Claire Dunne, Oral Hearing Metrolink Project, 27th February 2024, The Court Dalcassian Downs Glasnevin

Drawing Status: **FINAL**

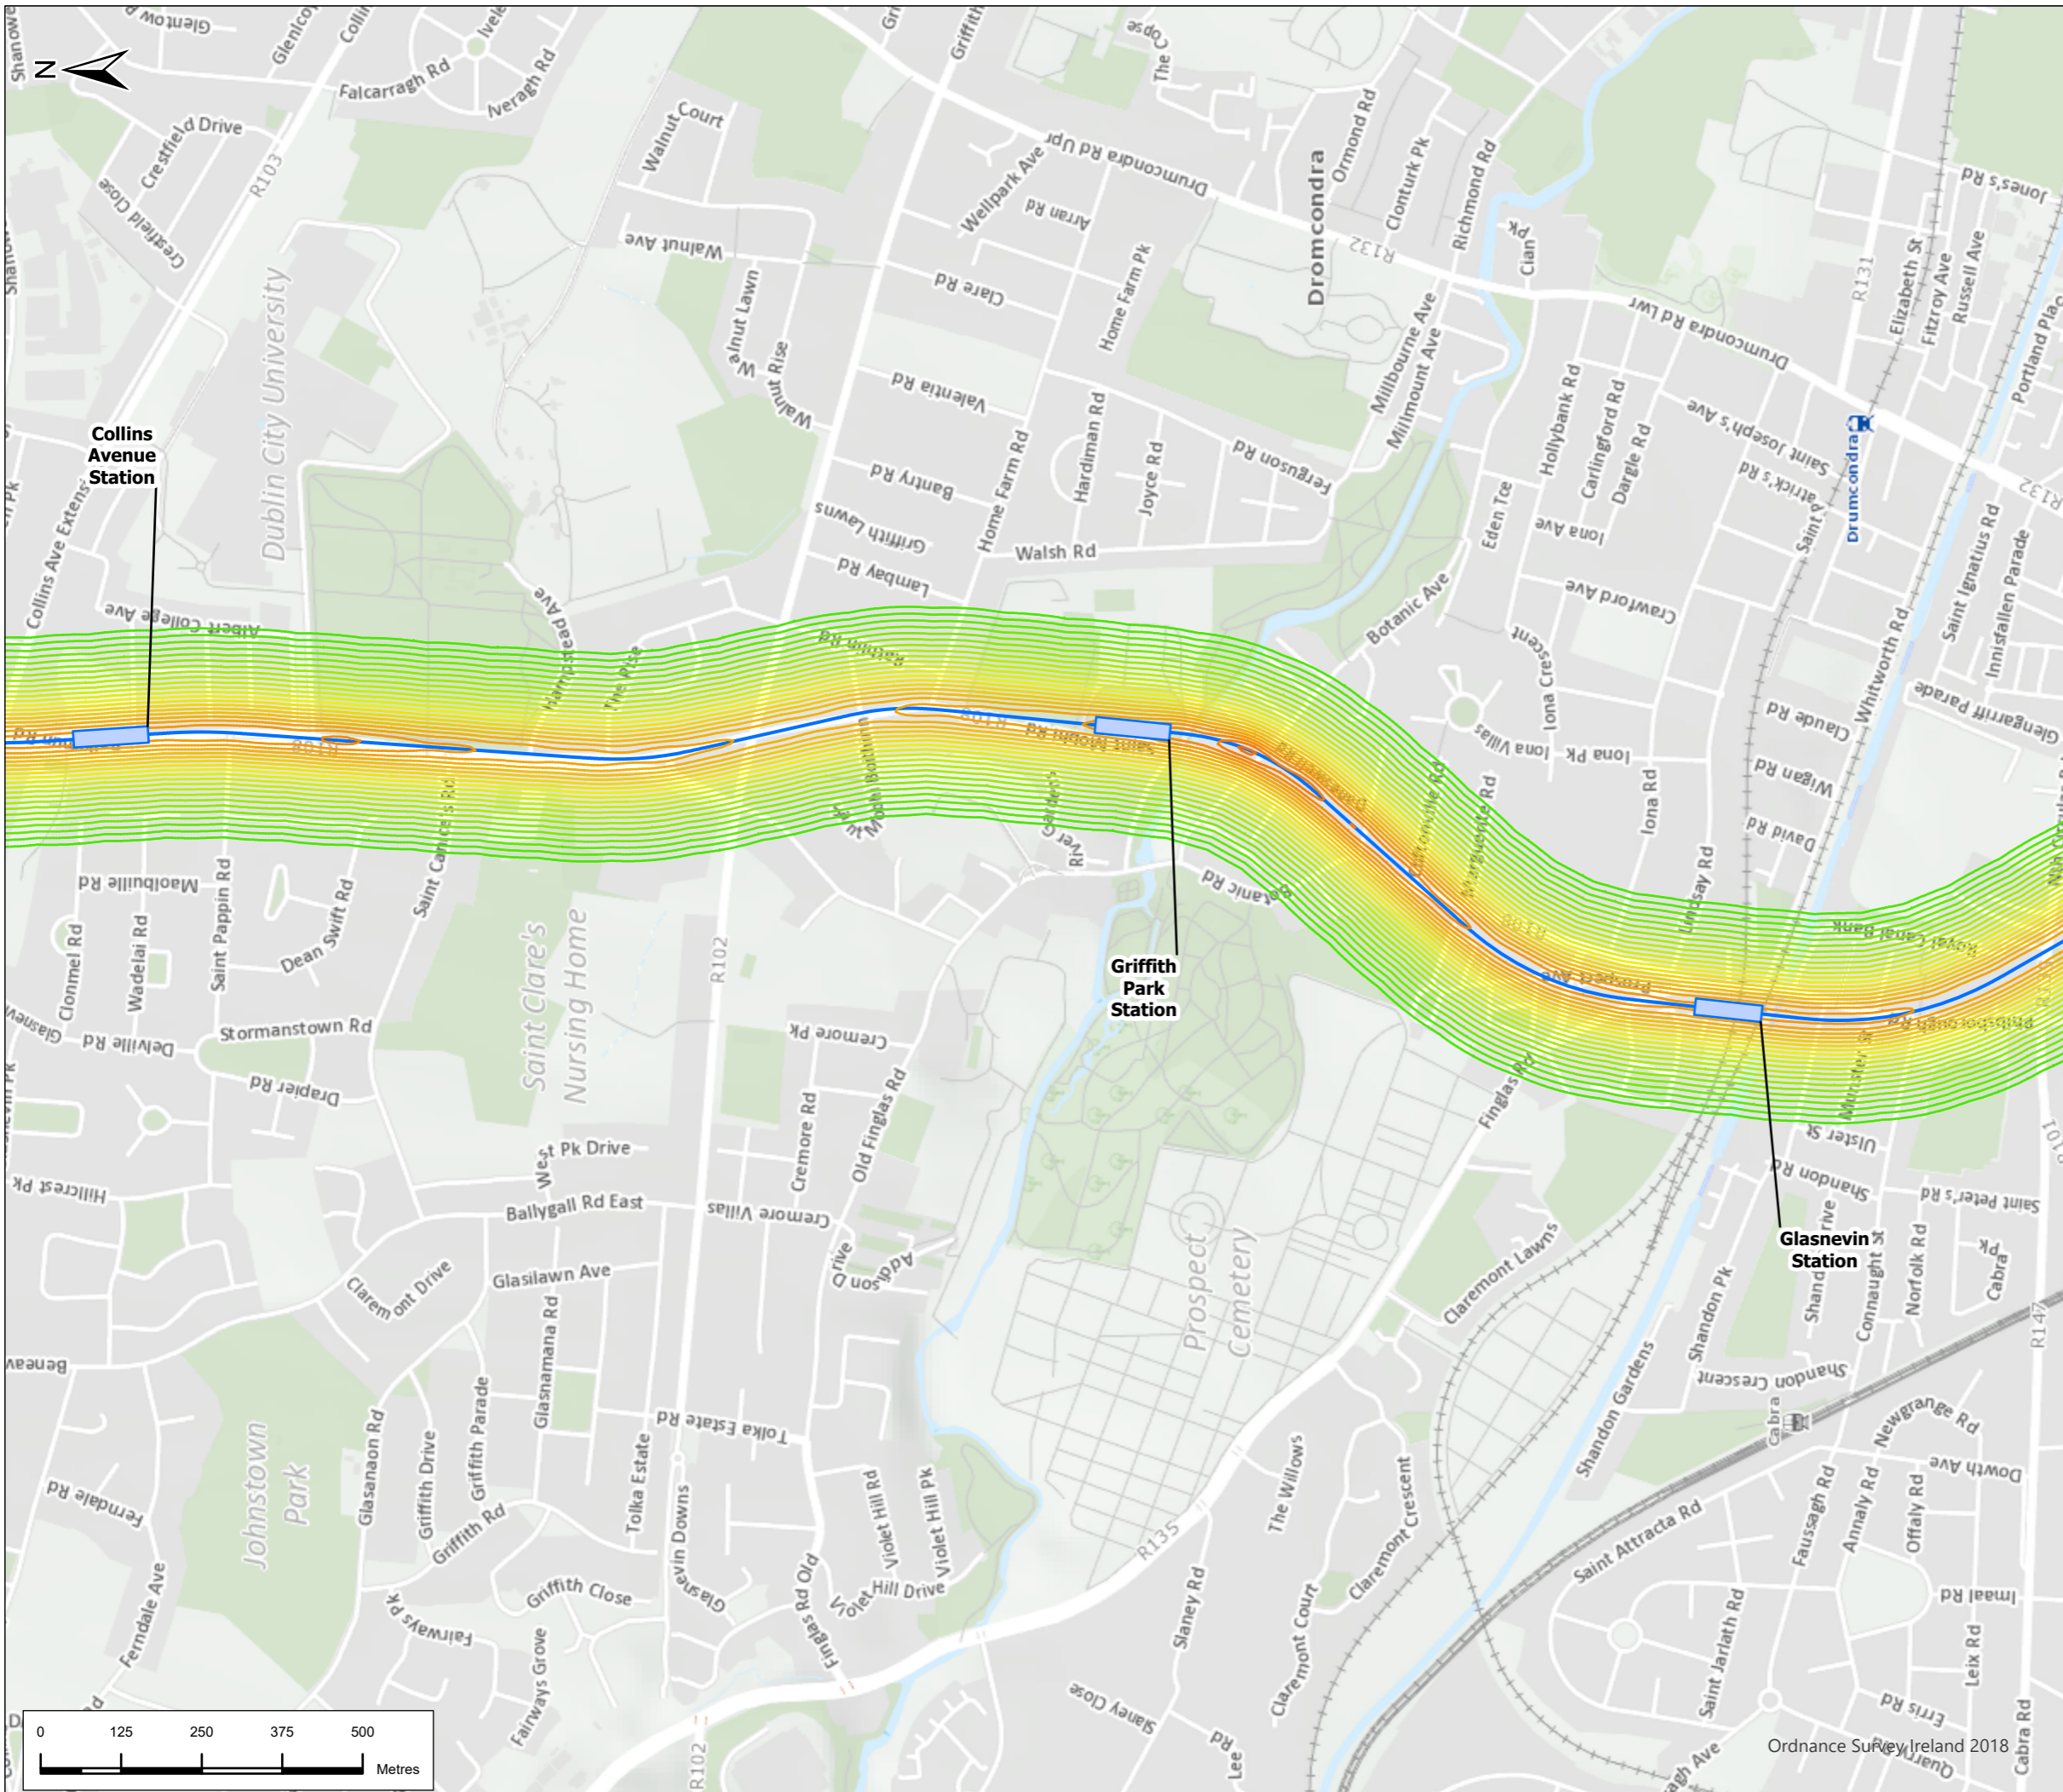
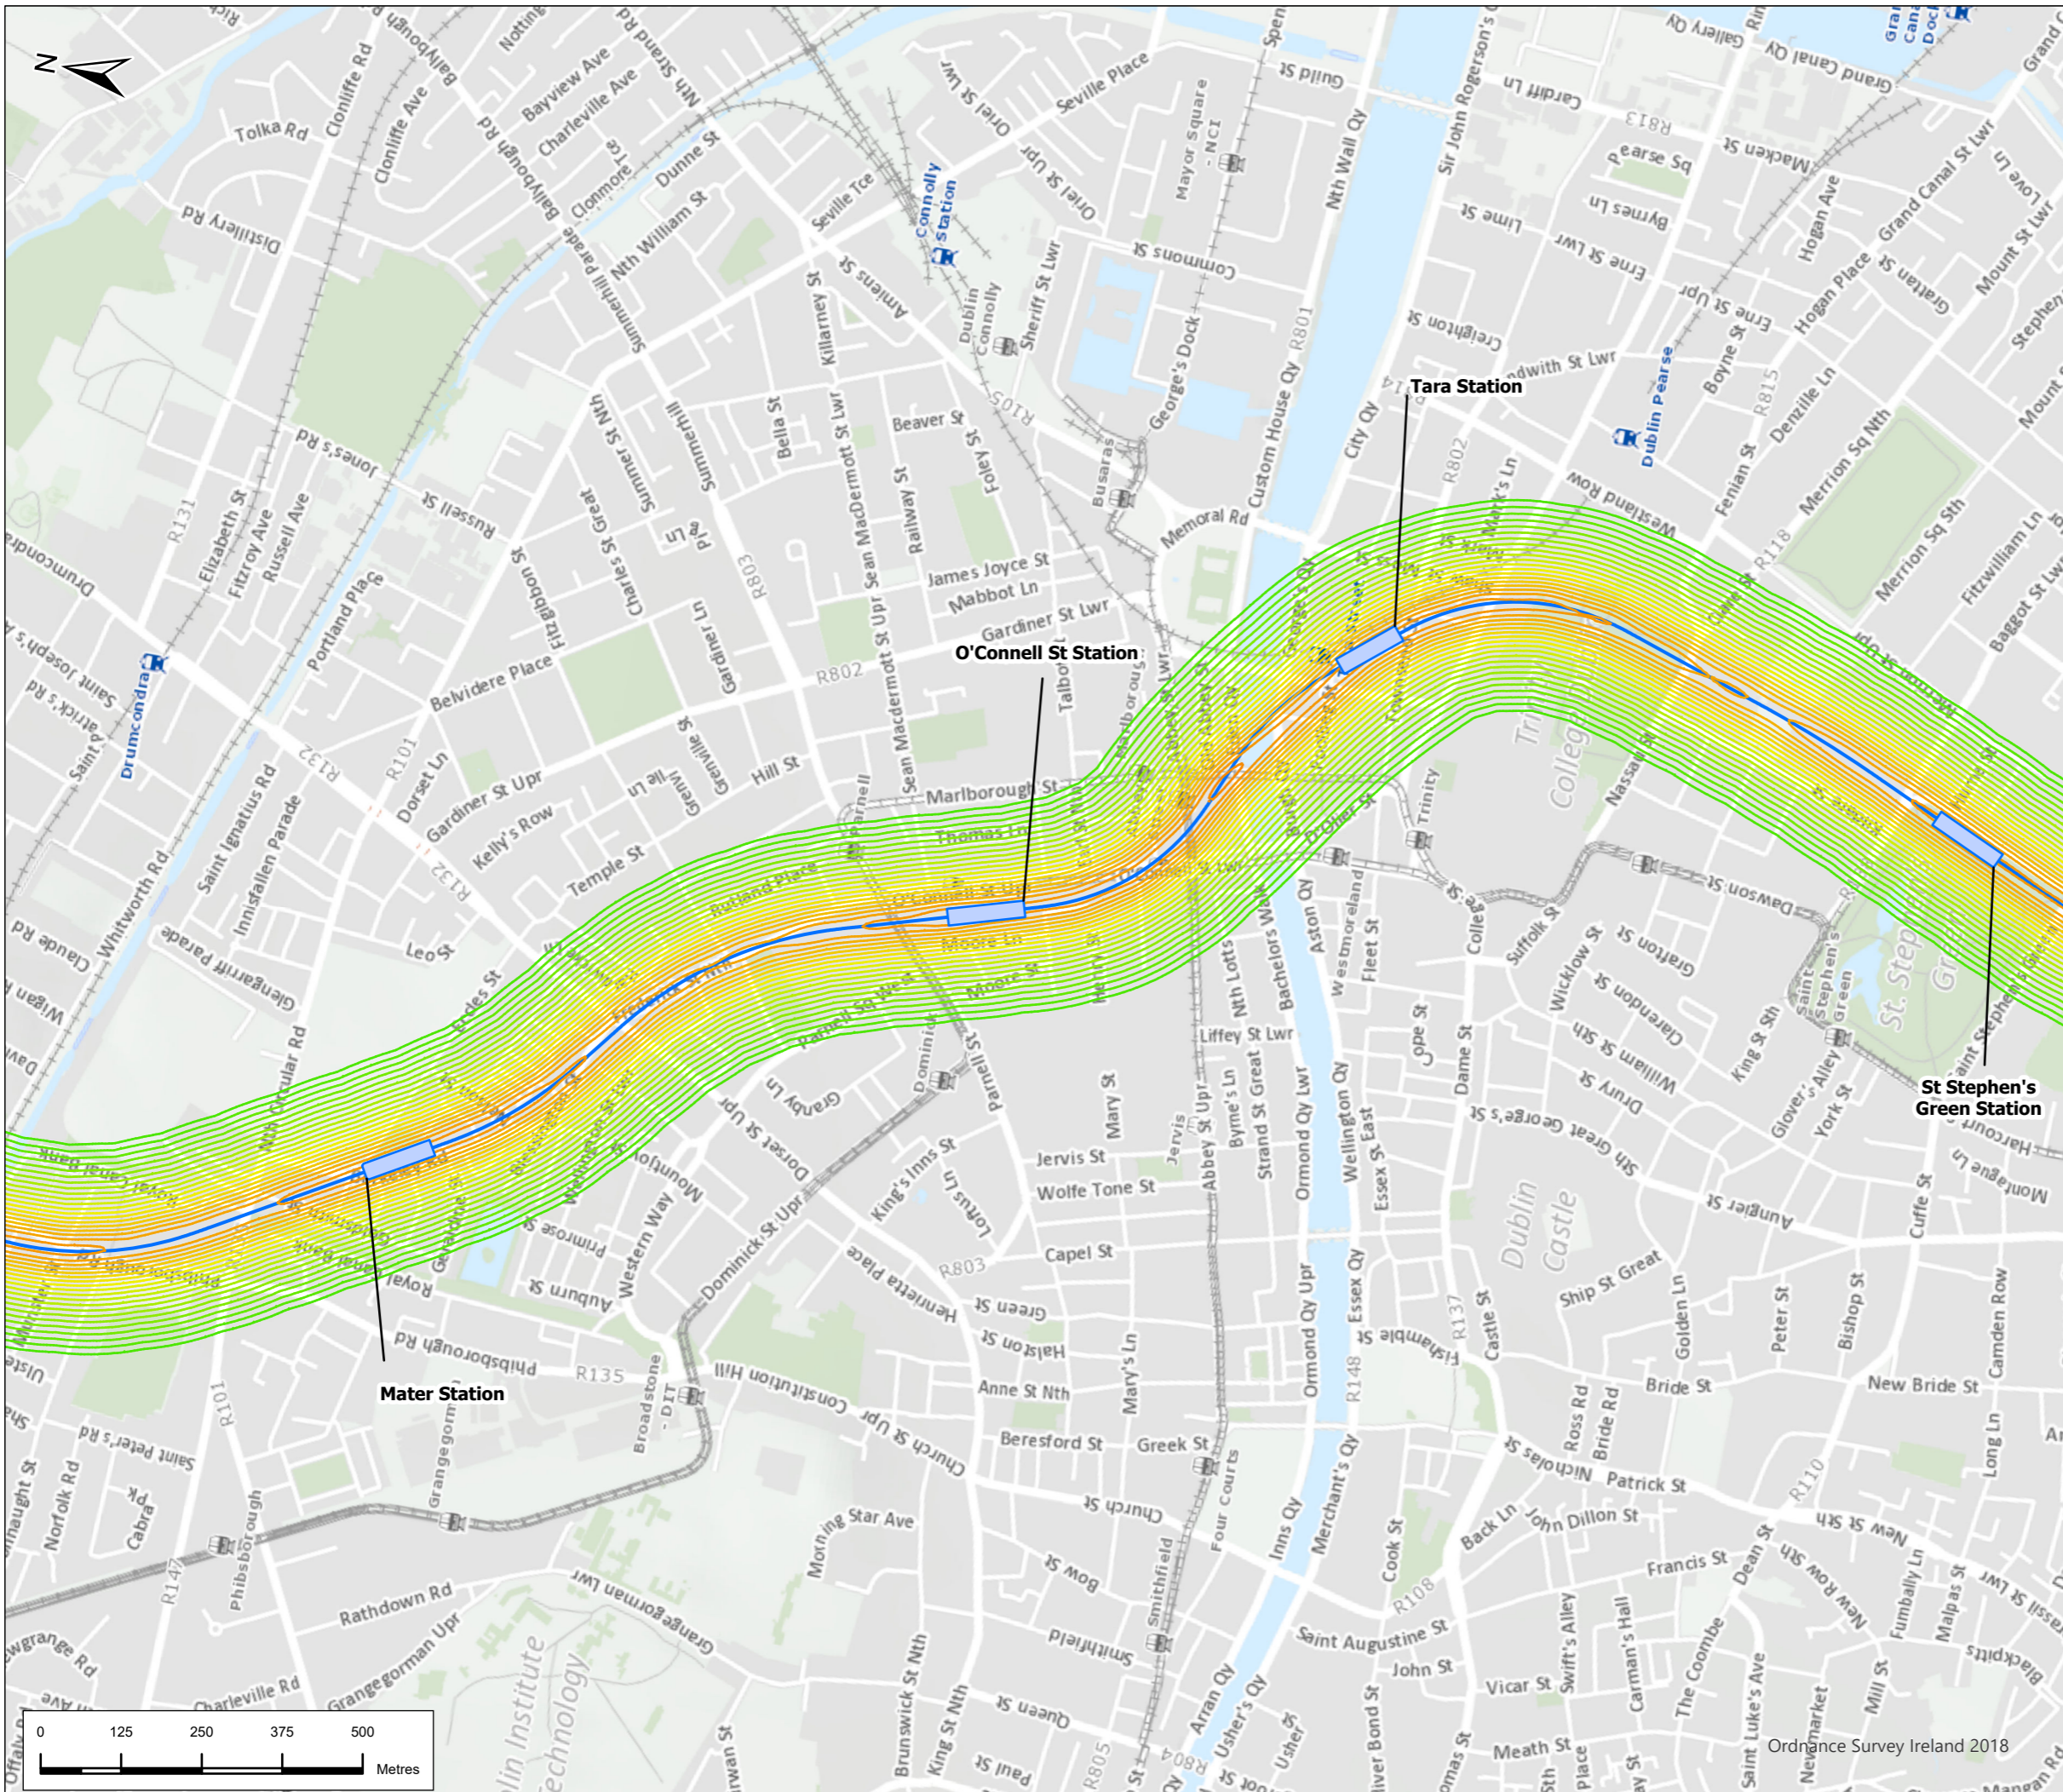
In response to my query in relation to groundborne noise and vibration you conceded that the groundborne noise while the TBM is passing below the apartment will be 49 dB, above that the threshold level of 45 dB. This will have a significant impact on the health and well-being of residents. You mentioned that TII will undertake advanced consultation and stakeholder engagement to prepare people for the passage of the TBM. What exactly does TII propose to do to minimise the impact on residents during this time? In terms of relocation how will you be able to guarantee relocation within the same area with the current rental crisis?
